Application number: 2025/62/93480/W	
What is the application for?:	Erection of 28 dwellings with associated landscaping and external works
Address of the site or building:	Land off Parkwood Road/Weavers Lane, Longwood, Huddersfield, HD3 4TT
Postcode:

Type of comment: An objection	
Do you wish your comments to be published on the website anonymously?	Yes
Formal Planning Objection	
Planning Application: 2025/62/93480/W Site: Proposed Residential Development	
Dear Planning Officer,	
I write to submit a formal objection to the above planning application.	
I wish to make clear that I am not opposed to residential development on this site in principle. My objection relates specifically to the siting and massing of Plots 26 and 27, which, unlike the remainder of the proposed dwellings, are positioned immediately against the boundary of my property	
This unusual and intensified arrangement results in unacceptable harm to residential amenity and conflicts with both national and local planning policy.

SECTION AA (PLOTS 26, 27 & 28)

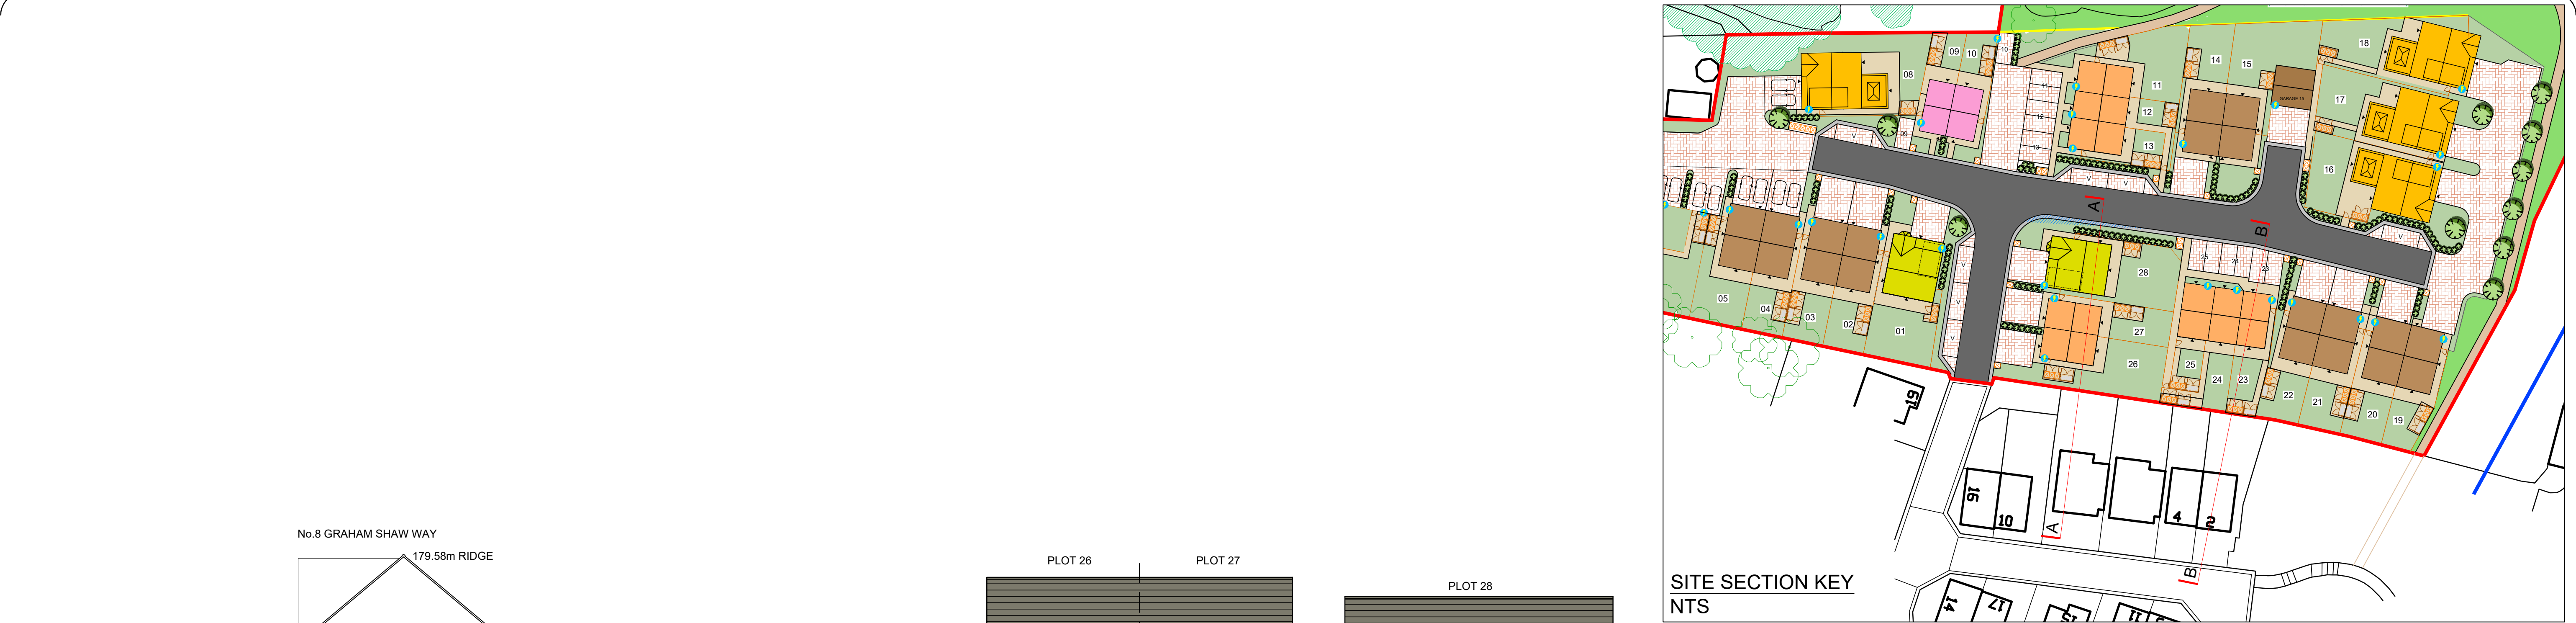
Due to their height, two-storey form, and immediate proximity, Plots 26 and 27 would create an overbearing built form along my boundary, resulting in:

The proximity and massing of Plots 26 and 27 raise serious concerns regarding daylight, sunlight and overshadowing. In particular:

the reduced separation distance compared to the rest of the site is likely to reduce daylight to rear rooms

the height and siting of the dwellings risk overshadowing my private garden during periods when it currently receives sunlight.

Depending on the final positioning of windows and ground levels, Plots 26 and 27 pose a risk of overlooking into my private rear garden and potentially into habitable rooms.

Indicative separation distances commonly applied within Local Plans appear not to be met. I request that the LPA require revised siting, reorientation, or appropriate window design (including obscure glazing where necessary) to ensure privacy is adequately protected.

The placement of Plots 26 and 27 directly against my boundary, when all other plots

benefit from generous spacing, represents poor and inconsistent design. It places an unreasonable burden on a single neighbouring property and fails to achieve a balanced or equitable layout.

Require a revised layout repositioning Plots 26 and 27 away from my boundary;
